Applicant: Albion Land (2013) Limited c/o Quod

Proposal: Discharge of conditions 9 (Phasing Plan); 10 (CMP); 11 (CEMP); 13 (AMS); 14 and 41 (Intrusive Investigation) of 19/01740/HYBRID

1.1. The application site relates to a parcel of land to the west of Bicester and east of Wendlebury Road. The land benefits from outline planning permission for B1 development on the main part of the site with full detailed planning permission for a health club within a smaller parcel within the north west corner of the site. Planning permission was granted under ref. 19/01740/HYBRID

Scale Date	1:750 @ A0 19.08.2020	Drawn Checked	JP JJ
Drawing number	11920_P03	Revision	A

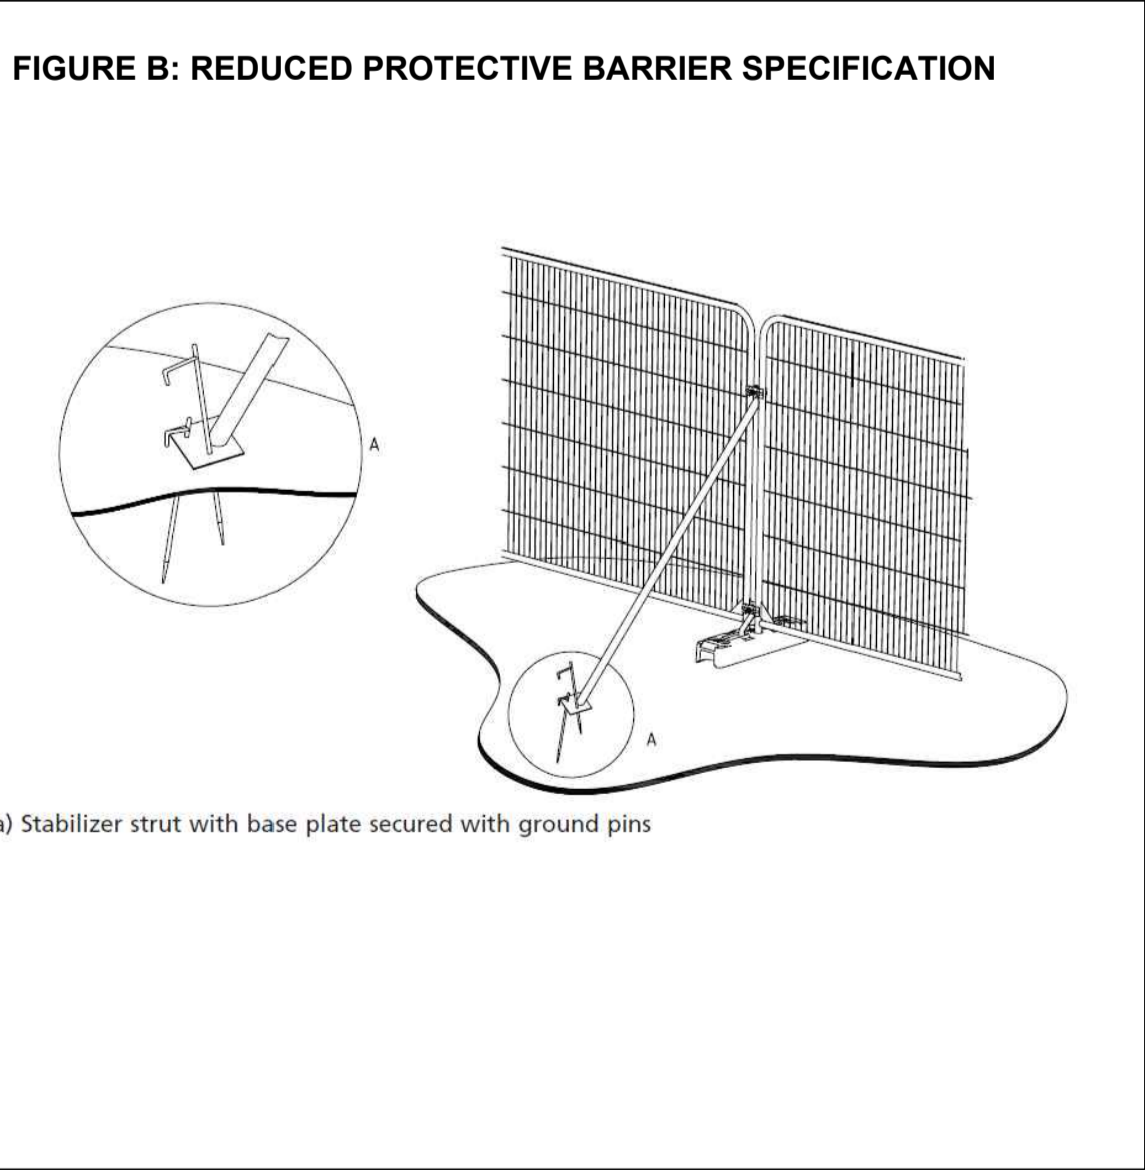
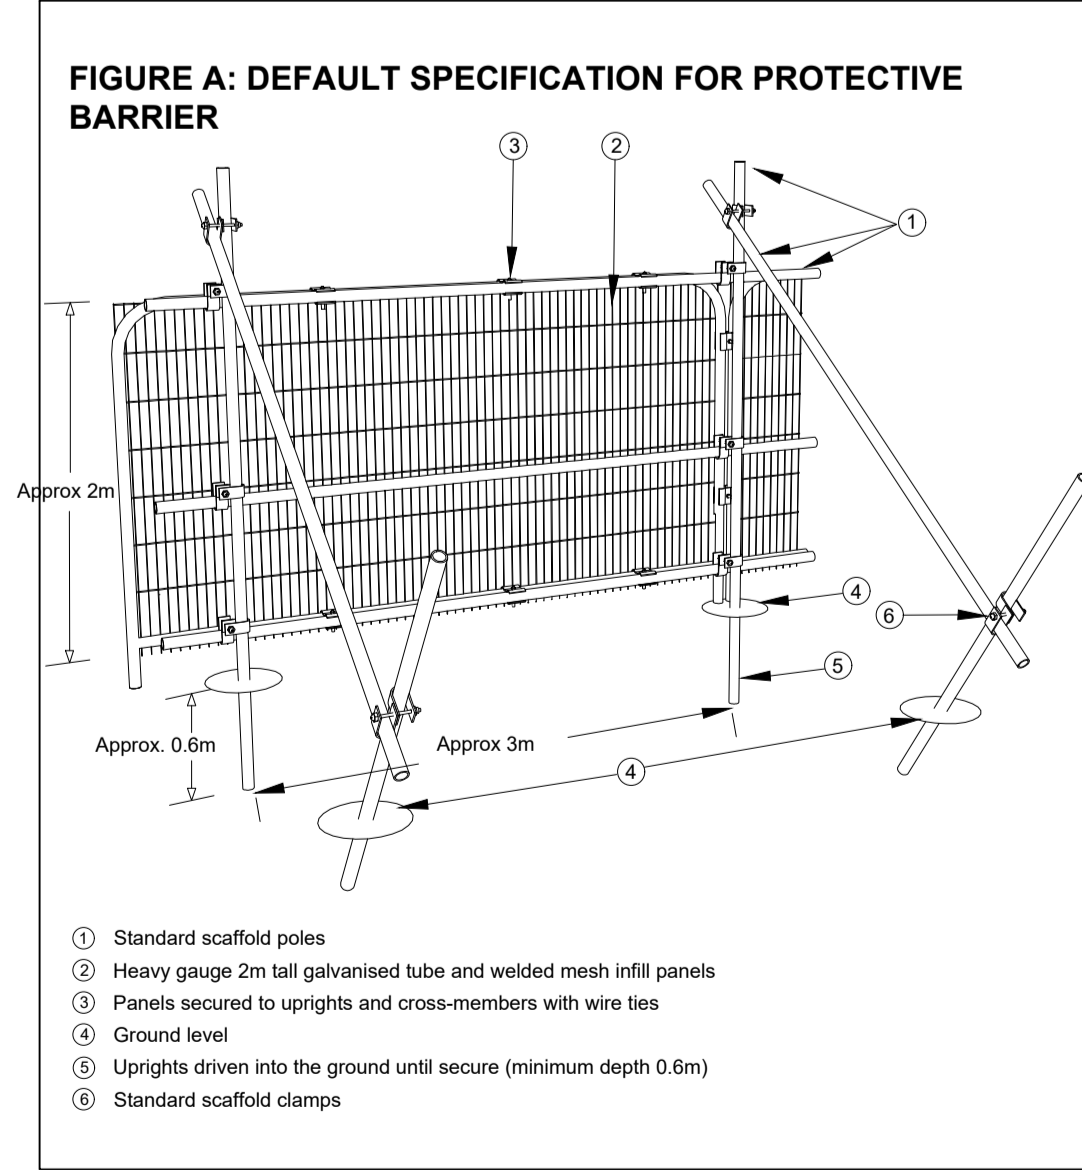
- 5.8. Condition 13 – CDC Tree officer has advised that whilst the submitted plan is not a full AMS as required by the condition, the submitted information is considered acceptable to discharge the condition for the DLL site.

ALBION LAND  
Drawing No. 18022 - SK - 123 Rev. D

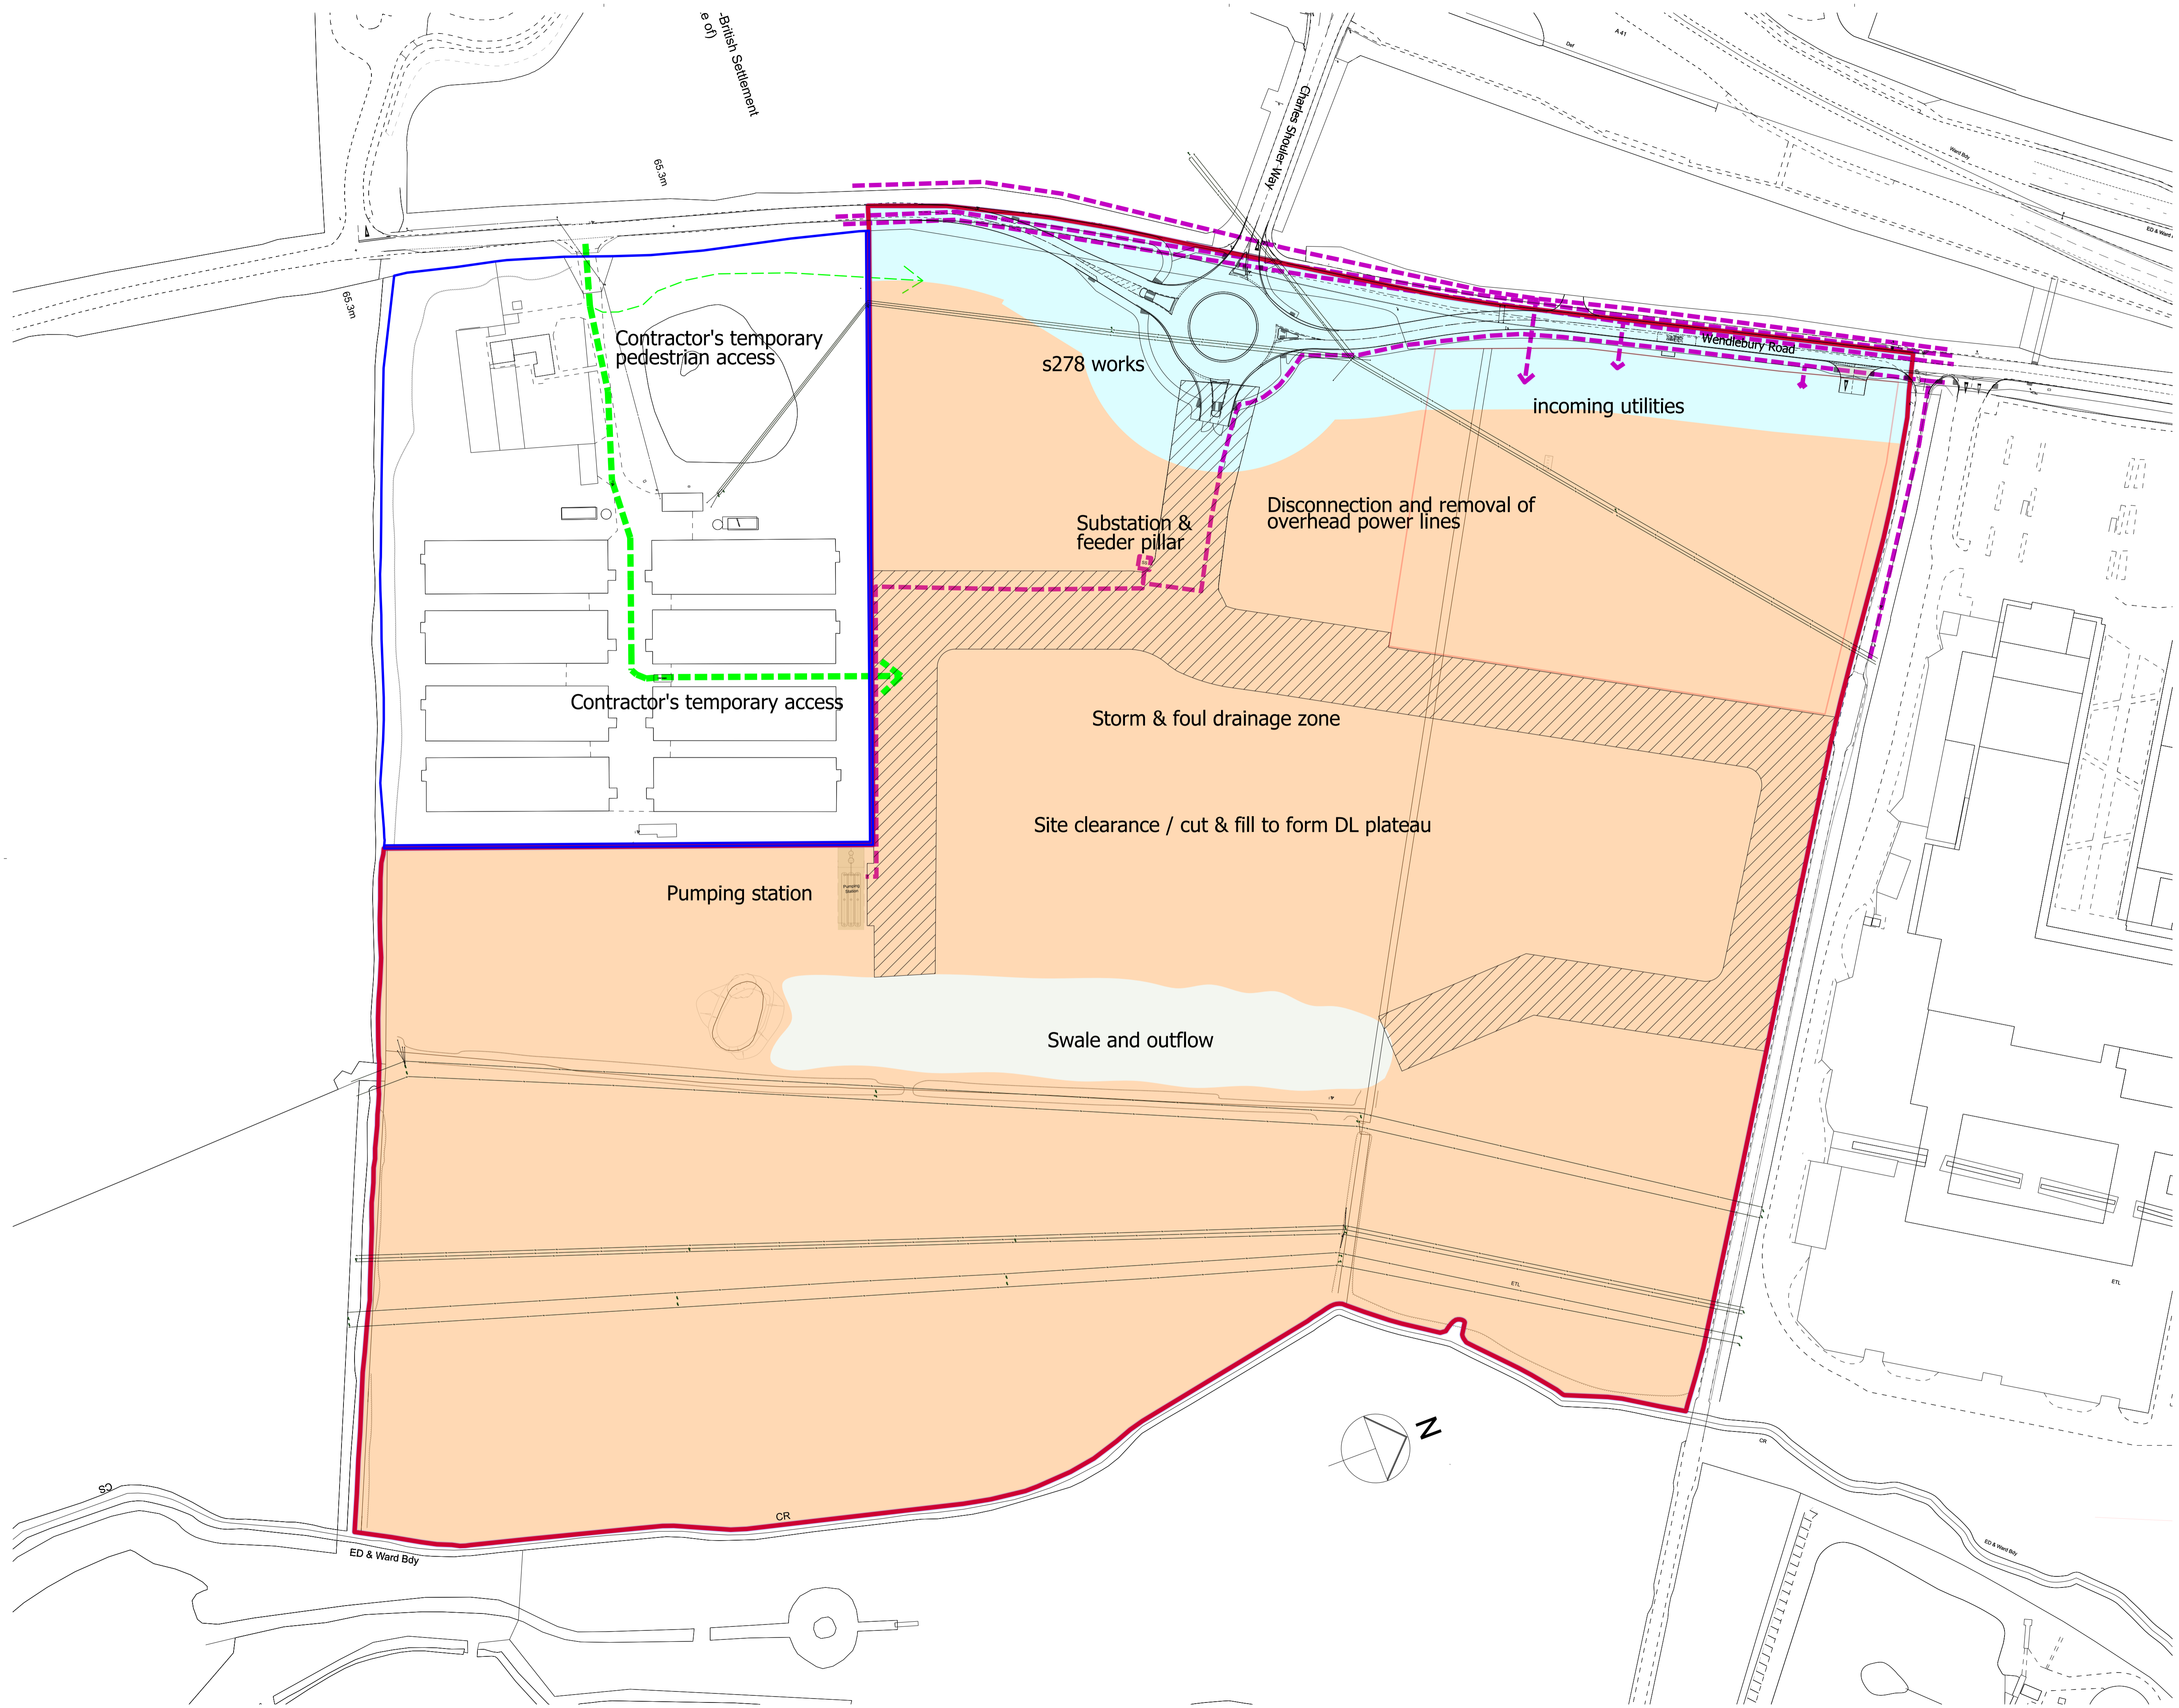
- 5.2. Plan 18022-SK-123D shows the works proposed as phase 1. This includes details of works across the entire outline application site as well as the full application/DLL site. It should be made clear that the discharge of this condition and the submitted plan is only approved in relation to the DLL site and not the wider site.

- 5.3. The applicant has confirmed that further condition discharge applications have been made to cover the wider site and that works will not take place until these conditions have been discharged.
